Recommendation Report for Planning Permission for Works or Extension to a Dwelling

REF NO: BN/7/22/HH

LOCATION: 10 Downview Road
Barnham
PO22 0EE

PROPOSAL: Erection of outbuilding to rear.

PROPOSED FRONT ELEVATION
(scale 1:50)

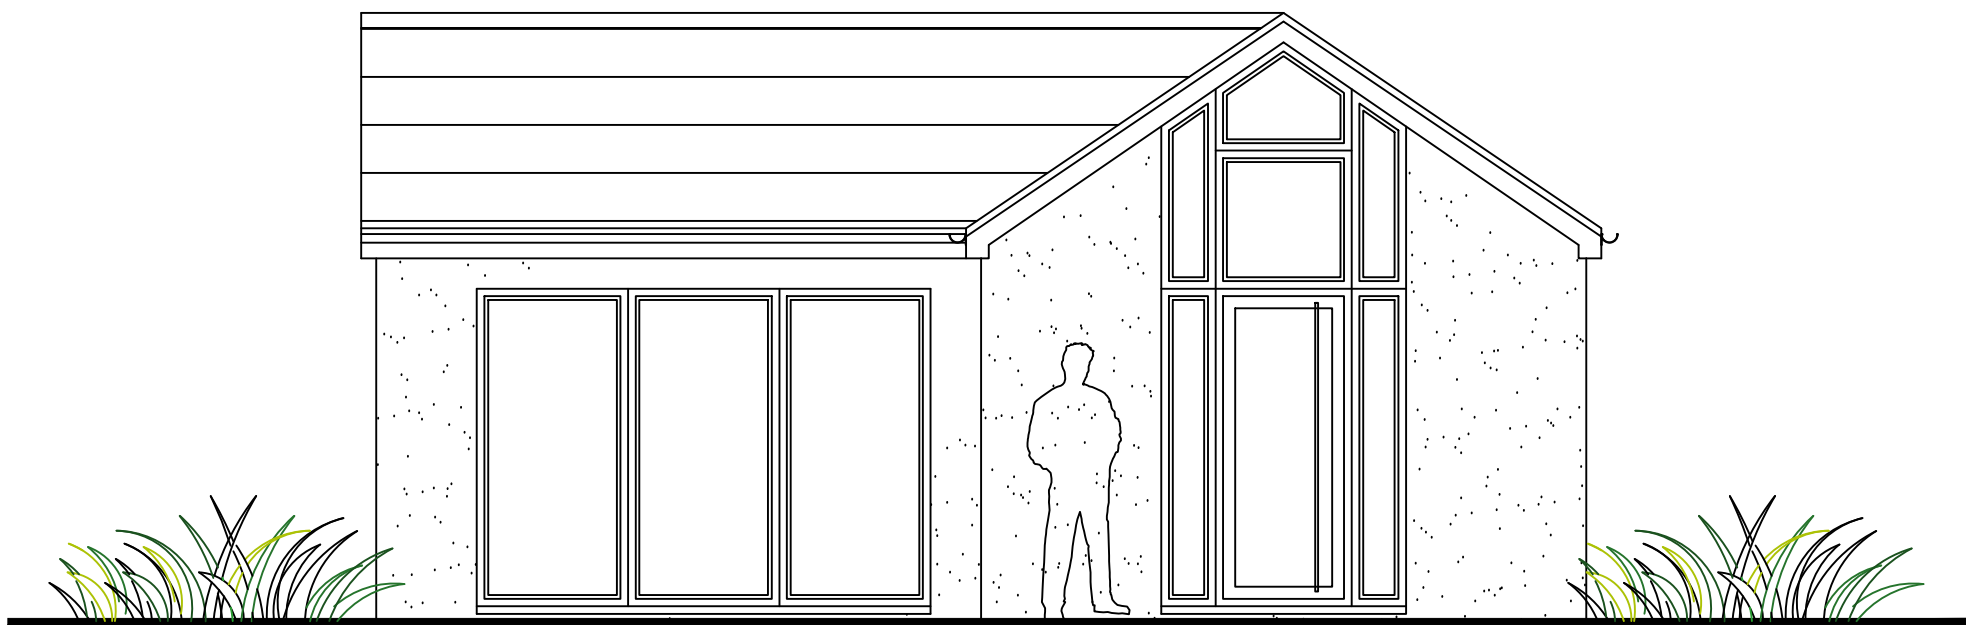
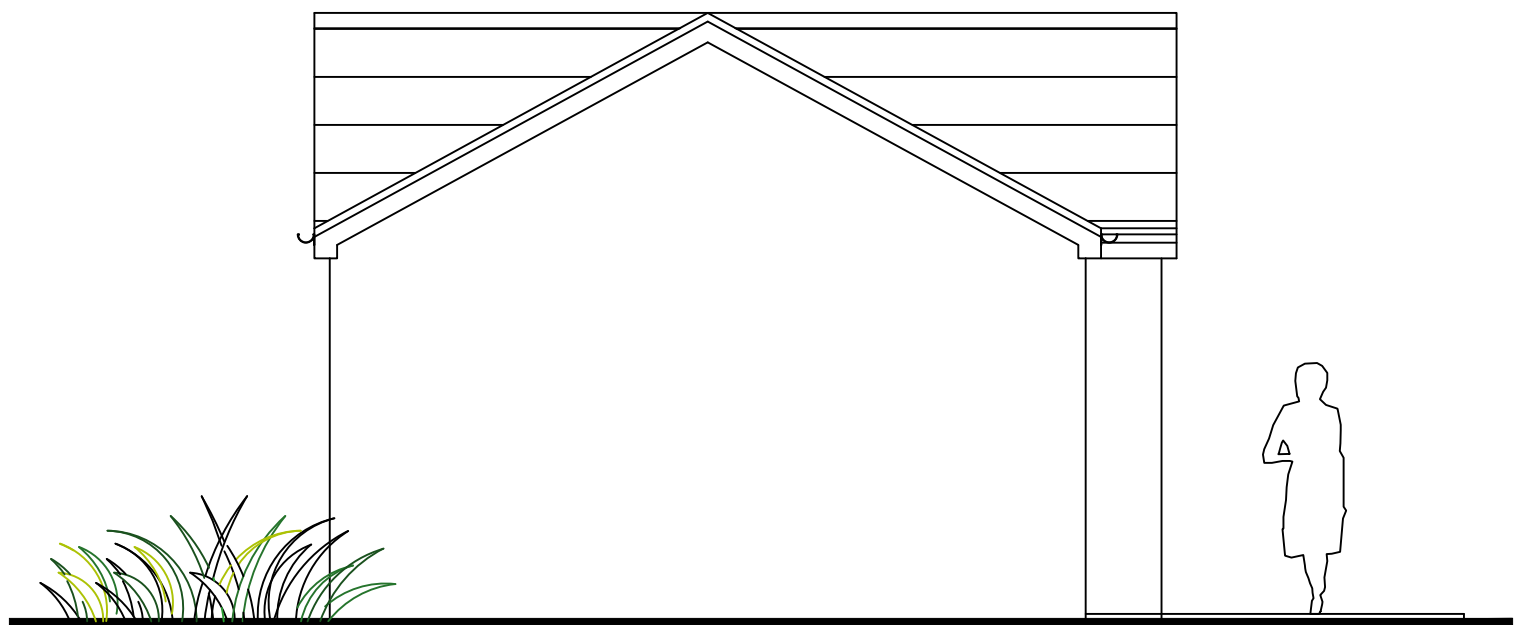
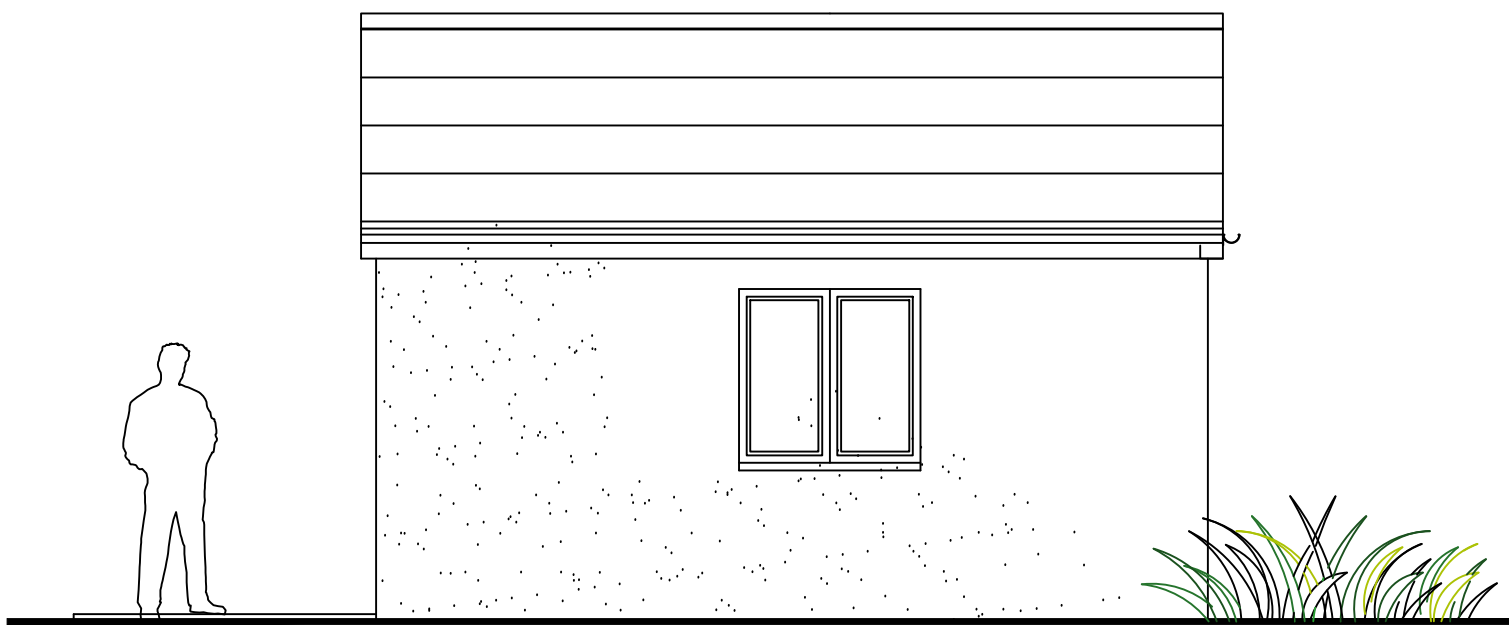
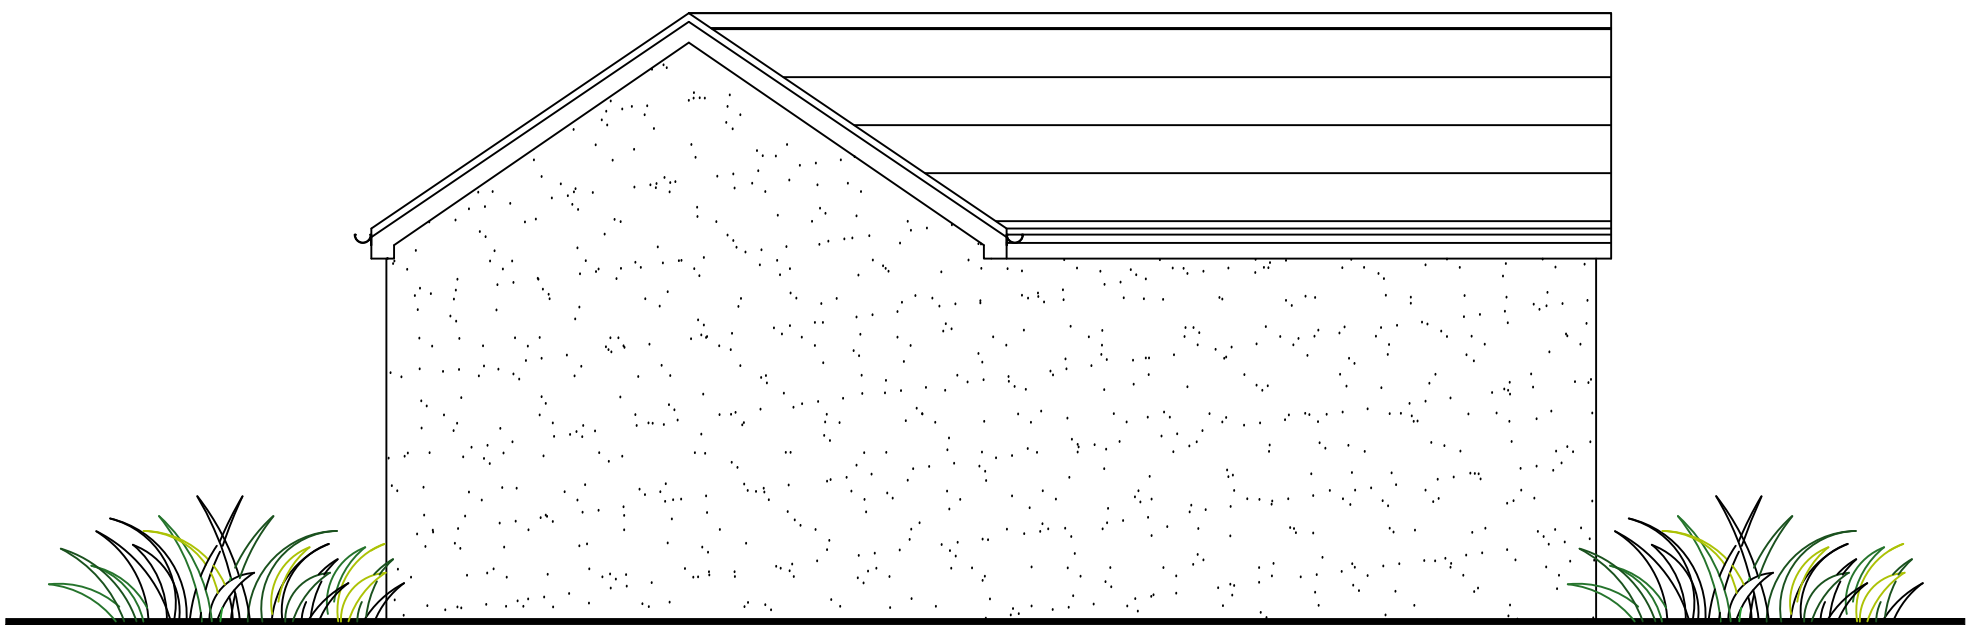
The outbuilding will be single storey, and measure a total of 8m wide and 5.5m deep, with another 2m in depth when including the proposed terrace to the front. It will have a gable roof, which will differ slightly to the main roof of the host. This will have minimal impact on the visual appearance and character of the property however, being that the proposed is a separate building and situated a significant distance from the host. As the proposal is located to the rear, it will not be visible from the street scene to the front of the property. This street scene is comprised of a variety of different style detached properties, all set back from the road on large plots of land. The proposal poses no risk of disruption to the appearance or composition of these properties, and is in keeping with the general character of the area. There is a small residential road running along the rear of the property, providing access to the neighbouring properties to the back of the host. The proposal will be situated 2m from the boundary separating this road and its properties, and given its scale, will be partially visible above the fence line. This visibility will be fairly restricted however, due to a number of trees situated along the boundary. Therefore, the impact on visual amenity from the street to the rear will be very limited, and as such is acceptable.

The proposal appears relatively subservient in design to the host, and will not appear unduly out of place in its context. It will primarily use materials matching that of the existing, the only exception being the walls. These walls will be brick and render, only similar in part to that of the existing walls of the host, which are a mix of white render and light grey cladding. Despite this, there will not be a substantial difference in the visual appearance of both buildings, and as a result, will have little intrusion on the character of the property, and the locality.

The outbuilding will be single storey, and have a gable roof. This roof will have a height of approximately 4m, and 2.6m at the eaves. A distance of 4.335m to the north, 5.287m to the south and 2m to the west boundaries will be retained by the proposal. It will also be situated around 42m from the rear elevation of the host property, and as such a similar distance from No.9 and No.11 to the sides of the host. Therefore, despite being 4m high, the proposal is located a sufficient distance from the neighbouring properties to the sides and rear, and will not result in adverse overbearing or overshadowing. It poses no risk of unacceptable harm to residential amenity, and is in accord with D DM4.

The outbuilding will face toward the host dwelling, and will provide separate internal space to be used as a gym and playroom. It will feature a bi-fold door, windows and single door to the front (east) elevation, and window to the north elevation. These features will directly overlook the garden, and potentially have views of No.9 and No.11. However, being single storey, and a significant distance from these properties,

they are not considered to be unduly harmful to neighbouring privacy or amenity. This risk is also reduced by the boundary treatment on either side of the property, which features a large number of hedges and bushes, and limits any potential overlooking of these neighbours. There will be no windows or doors facing towards the neighbouring properties to the rear, and as such no risk of harm to their privacy or amenity in terms of overlooking.

PROPOSED SITE PLAN
scale 1:200

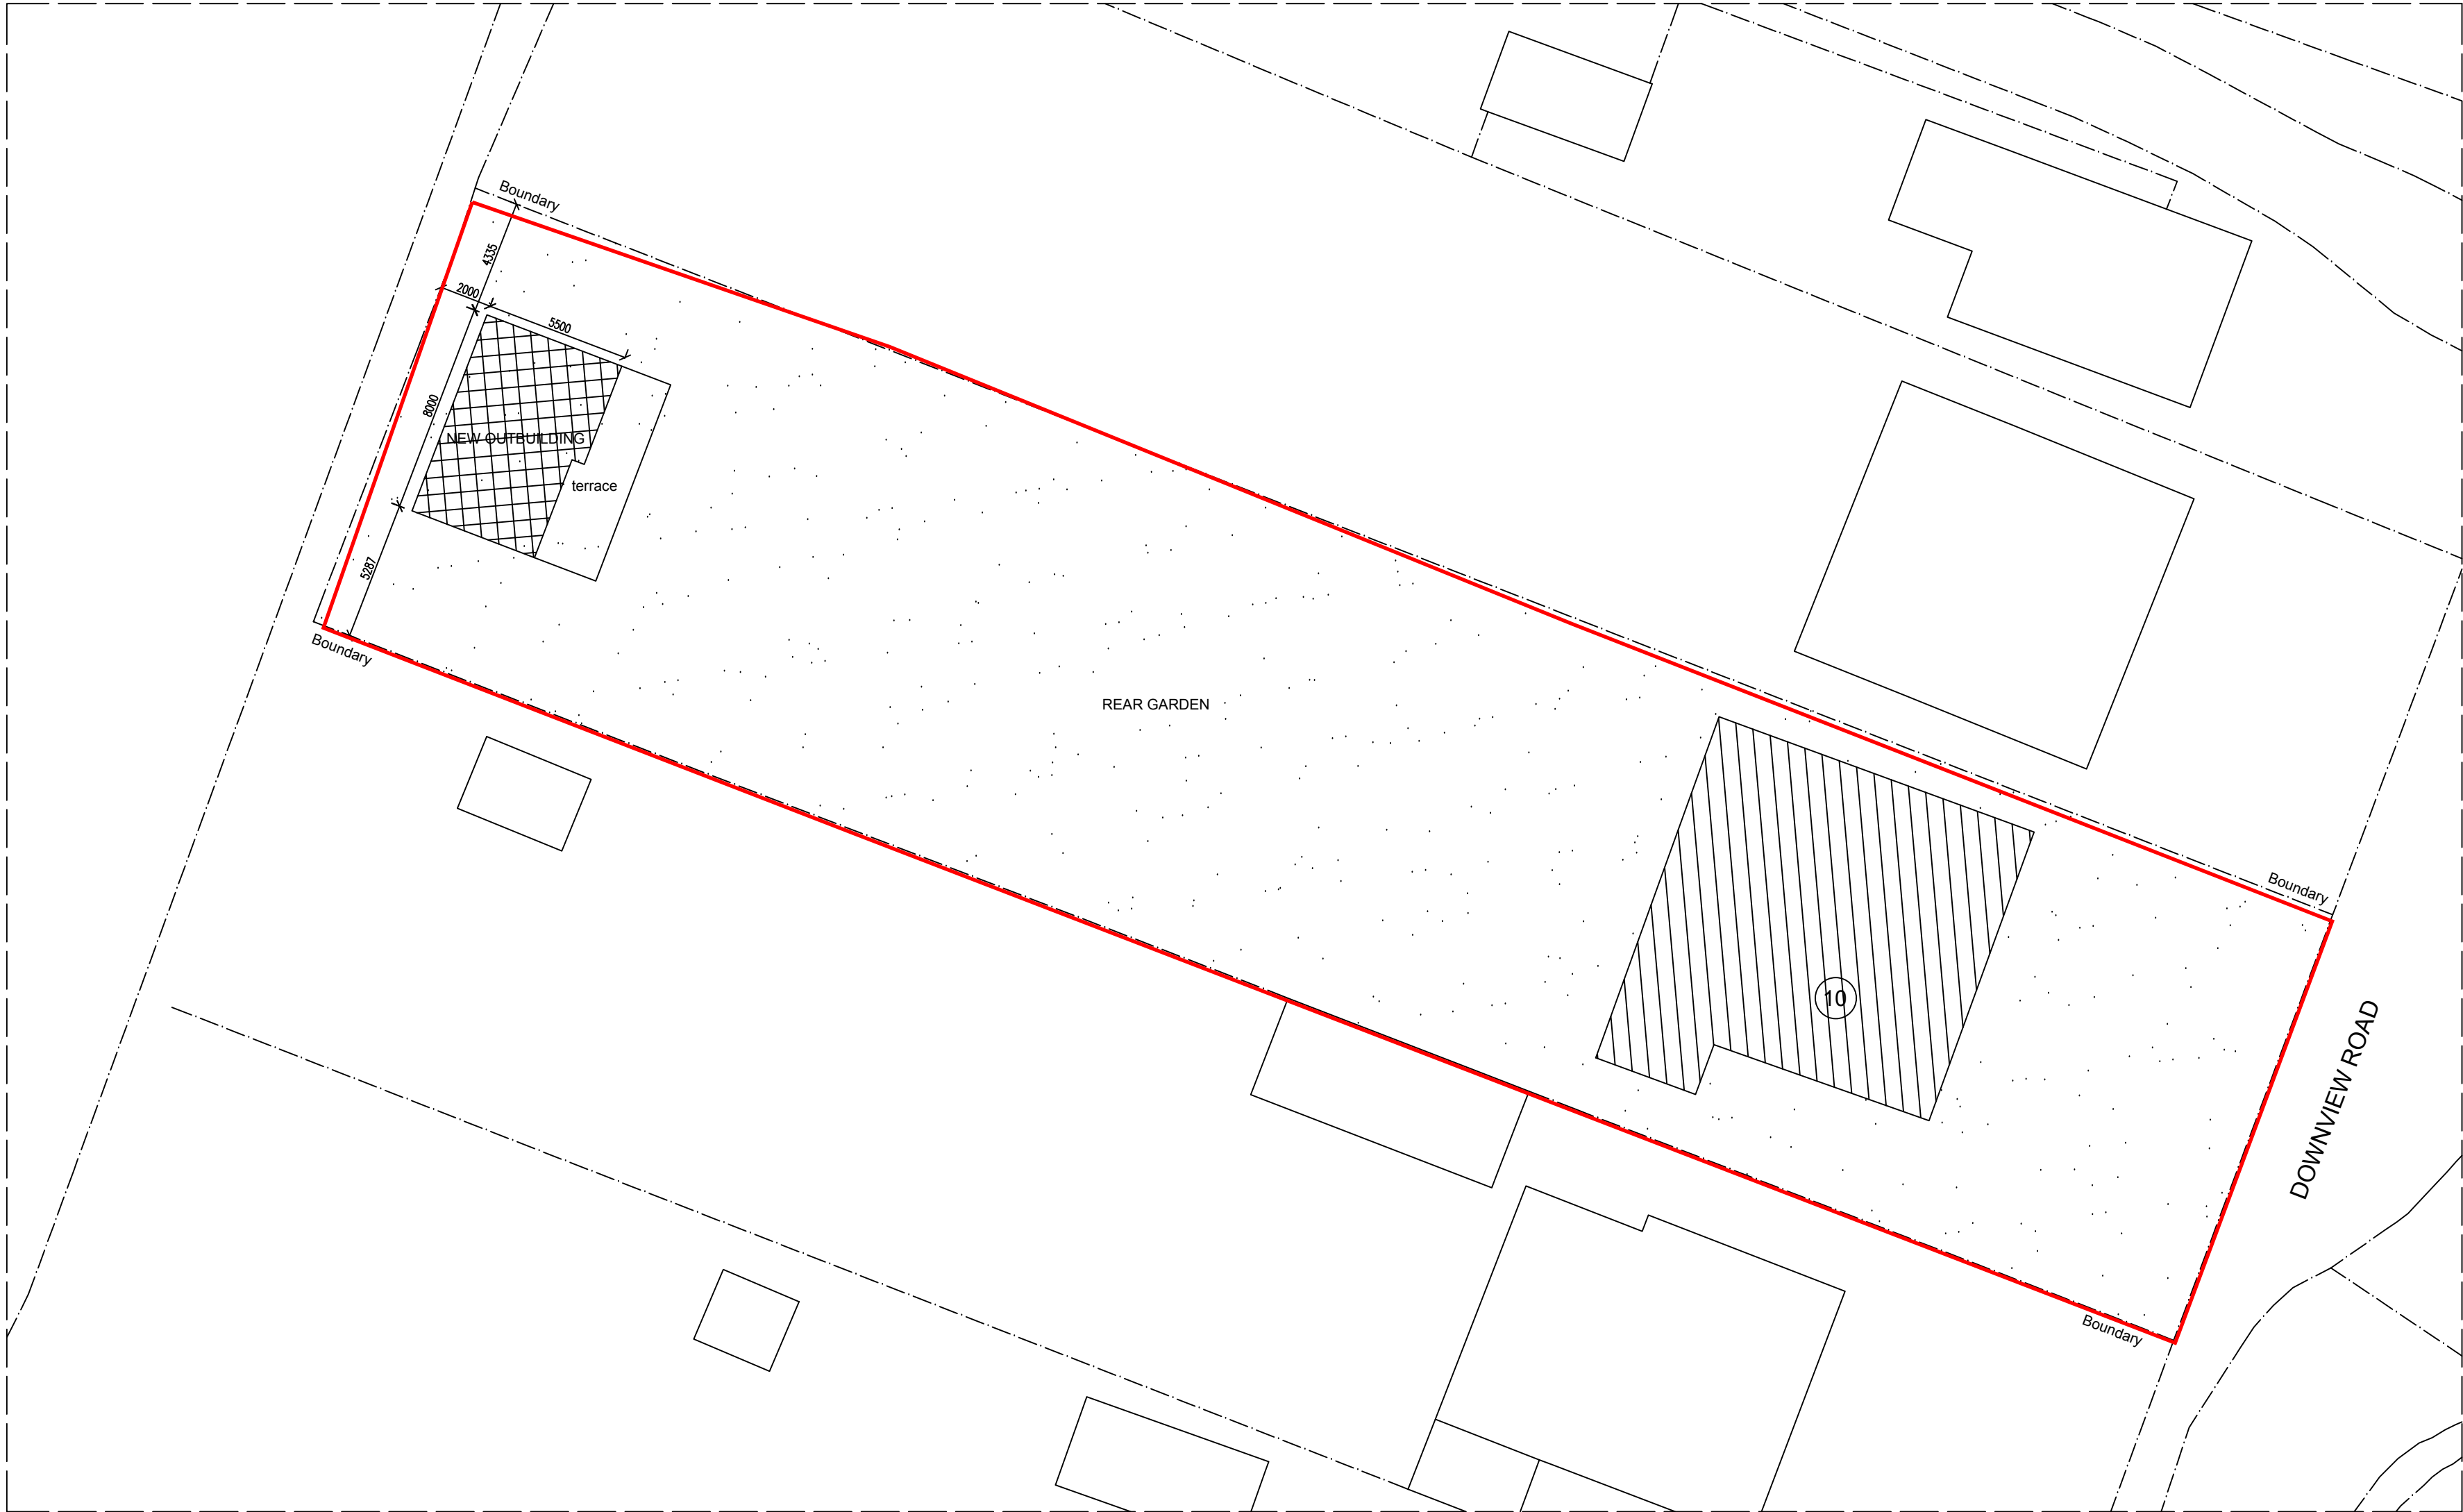
There are a number of trees situated along the rear boundary of the property, close to the proposed location of the outbuilding. The site is covered by a TPO (Eastergate No.1/68), but there is no individual order over these trees. Considering the distance retained from the boundary and the trees, it is unlikely the proposal will have an adverse impact on them, but care should be taken to ensure no harm is caused to their health during the development of the outbuilding.
